Application M/56/15/HH

31 Sea Way, Middleton-On-Sea, West Sussex, PO22 7RZ

We object to the plans under consideration at the above property. We moved to the estate in 1999 and have seen this house which is directly opposite ours change from a small, character cottage to an ever expanding structure, most of which is 'new build'. It is the equivalent of having two properties on the original plot. The character of the road at this point has already been unacceptably altered, including the addition of what seem to be large UPVC gates, and further overdevelopment must not be allowed.

ROOF PLAN
1.100

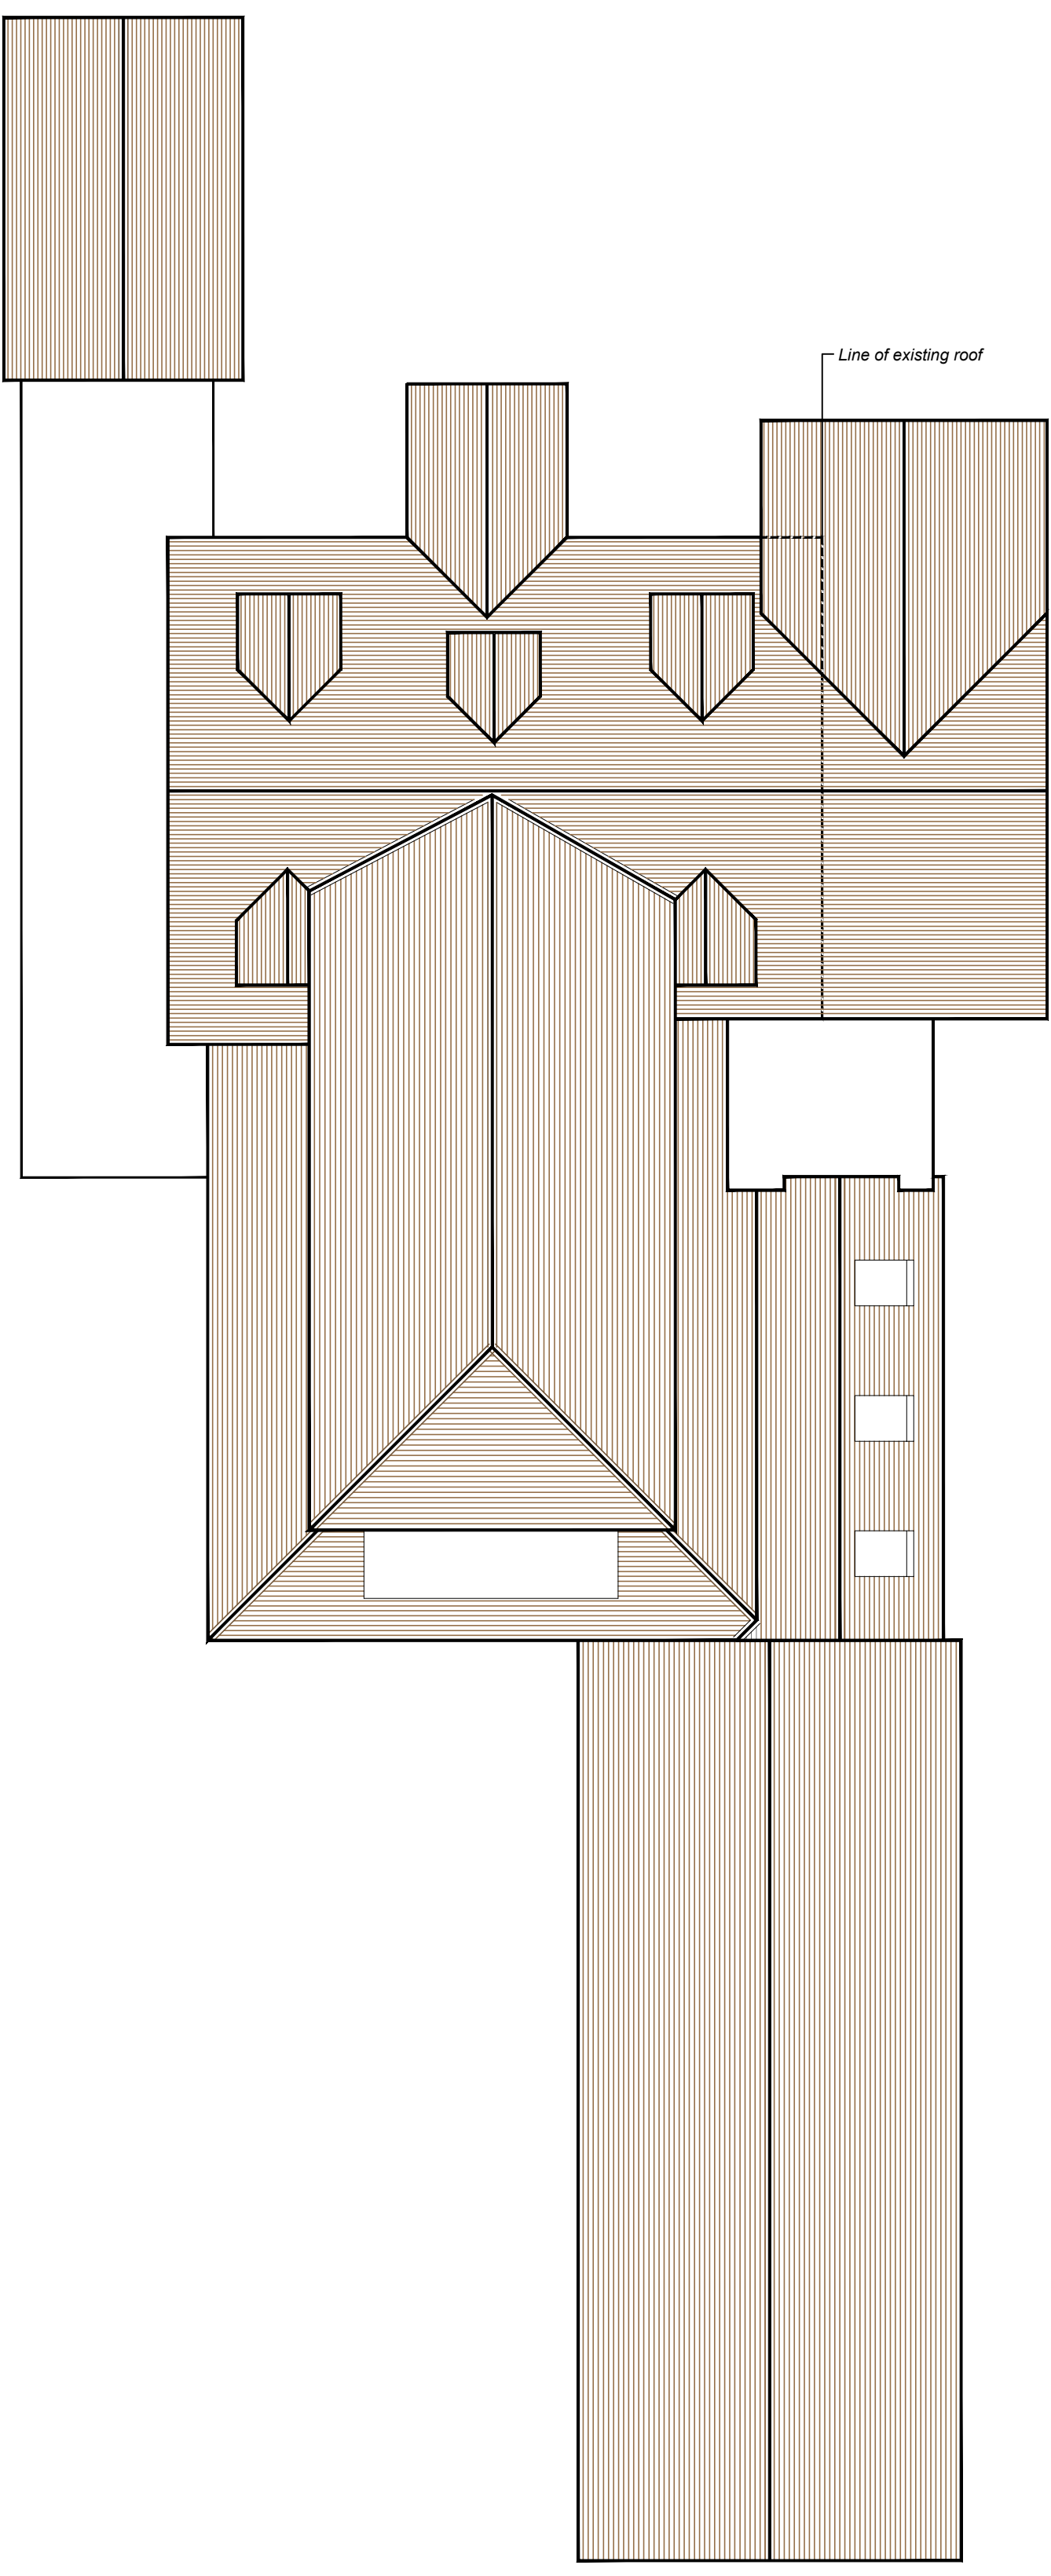
We find the proposed garage particularly disturbing. The plans blatantly breach the 'building line' adage and would result in the property being closer to the road than any other property on the estate. Surely this is not acceptable on this ground alone?

The proposed extension will be overbearing to the neighbouring property. The gap between the two is less than the accepted standard given the roof overhang. This will be evident to a planning committee viewing the site and must be taken into account. A previous application was made, I believe, by these residents to make a similar extension to the West of the property and was turned down on these grounds. Reference needs to be made to objections made at that application and considered in relation to trying to do the same thing on the other side.
